Attachment A - Liverpool Hospital Multi Storey Car Park SSD10388 – Response to Request for Additional Information

Figure 8 On-grade car parking – additional tree planting

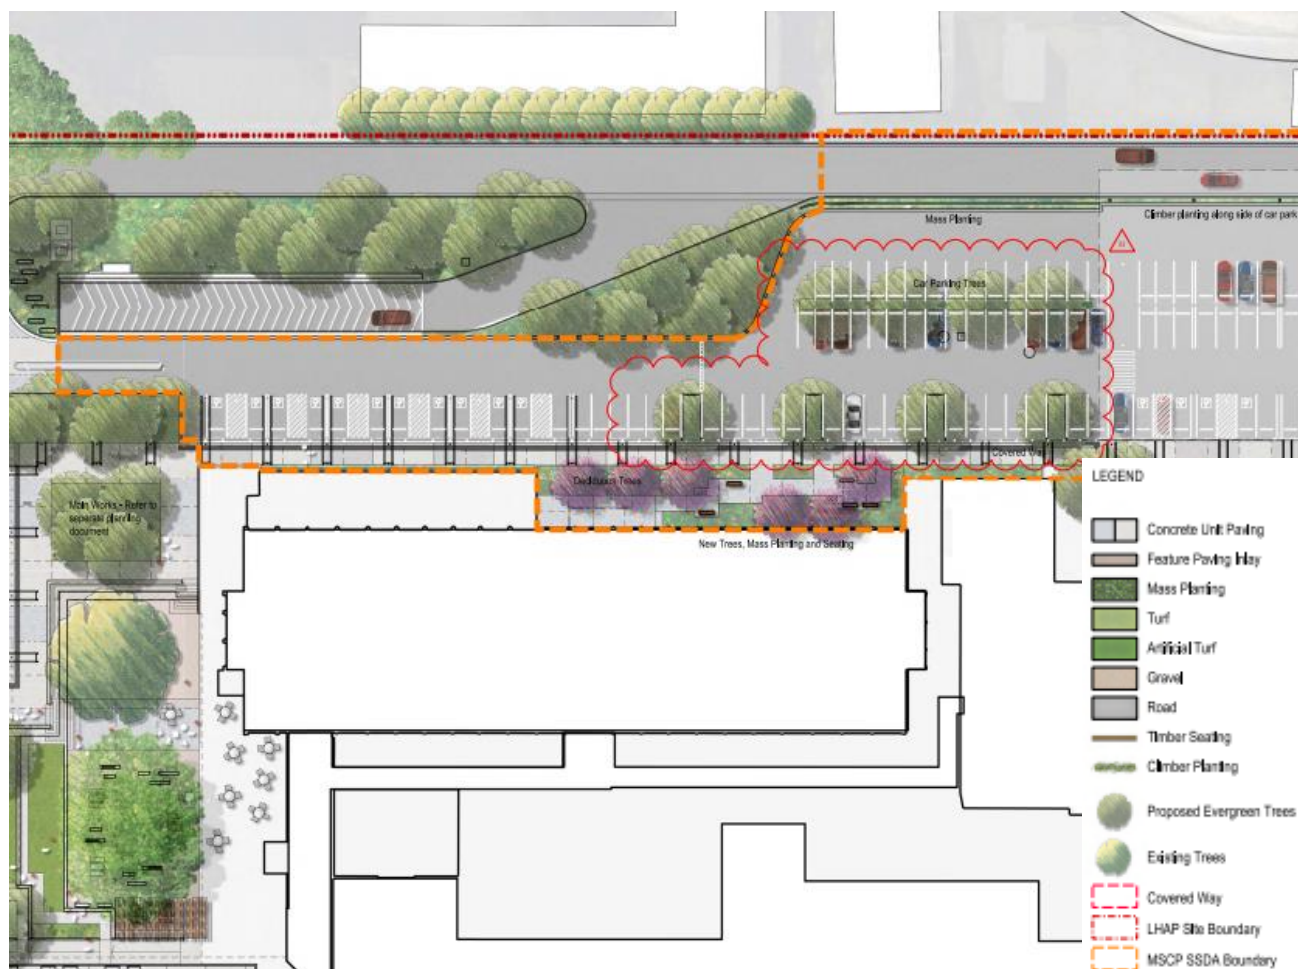
<p>It is also recommended that peripheral planting zone on the roof top level is incorporated within the building design that will allow for green roof coverings on pergolas/trellises at the roof level.</p>	<p>It is further noted that additional 8 trees will be planted in the on-grade car park as part of the MSCP development.</p>
<p>The revised planting palette is supported. Ensure that the proposed trees/vegetation is provided with adequate soil volume to maximise the growth potential.</p>	<p>Sufficient soil volume has been provided for all trees and vegetation.</p>
<p>The landscape plans show climbing vegetation to be grown on trellises on ground level, on the building façade, under the building overhang. Ensure that the proposed vegetation will receive adequate sunlight (i.e. under the building overhang) and has access to top up irrigation to support plant growth during peak summer months.</p>	<p>Vegetation will receive northerly sun and irrigation from roof water to a wicking bed system with top up irrigation in extended dry periods.</p>
